City of Albuquerque Stormwater Construction Site Inspection Report

ESC File No.	K09E048B	Project Name:	Dutch Brothers
NPDES Id. No.	NMRI005FQ	Location:	210 98th St NE
8/30/2023	Owner	Contractor	
Operator	Heritage Trails Development, LLC		
Contact name & title	John Caglia		
e-mail	john.caglia@dutchbros.com		
Contact Phone #	714-883-9092		
COA Inspector	Chancellor English	Start/End Time:	1030am
Construction Phase:	infrastructure nearly complete		
Type of Inspection:	Regular	Storm Event	Post Storm Event >0.25"
		311/Complaint	Follow Up
Weather at time of inspection?	Clear	Temperature: ~	85
Estimated date of last storm 0.25" or greater	8/8/2023

DUTCH BROS. COFFEE - NM0203, ALBUQUERQUE, NM
EROSION AND SEDIMENT CONTROL PLAN

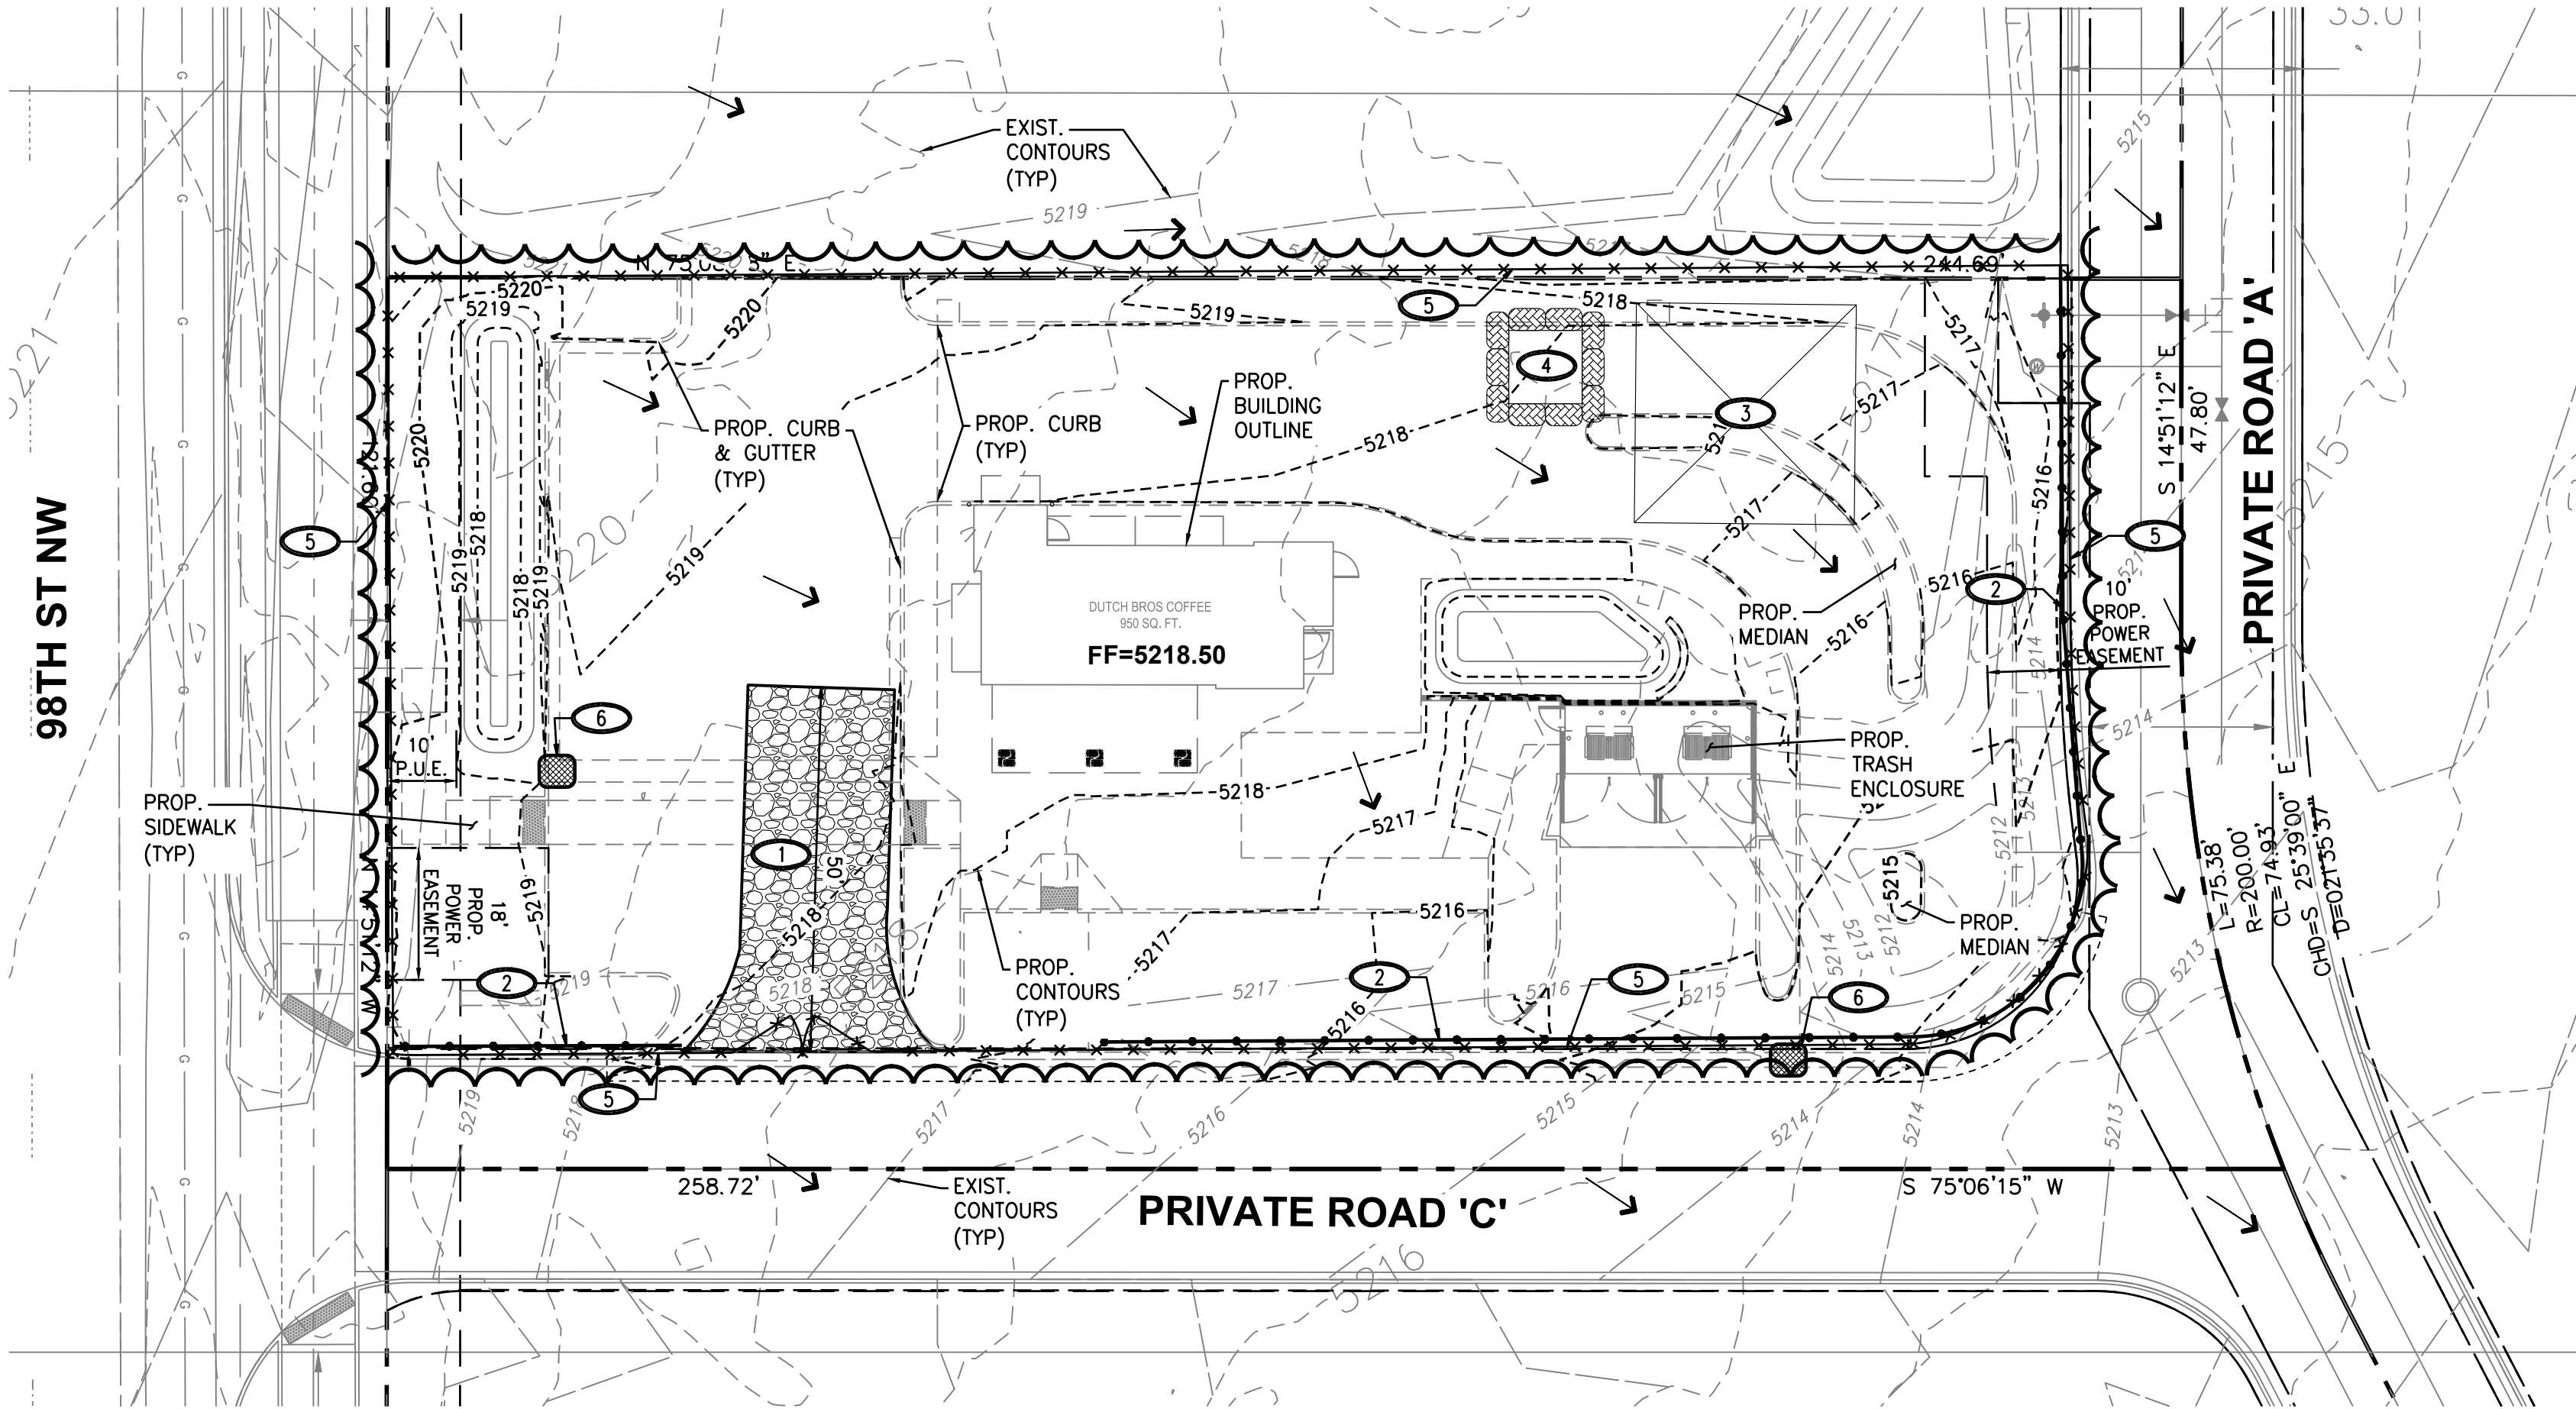
3	The are multiple gaps in the perimeter silt fence in violation of CGP Parts 2.1.2 and 2.1.4. Required mitigation: You must design and install all stormwater controls in accordance with good engineering practices, including applicable design specifications per CGP Part 2.1.2. You must ensure all stormwater controls are maintained and remain in effective operating condition during permit coverage and are protected from activities that would reduce their effectiveness.
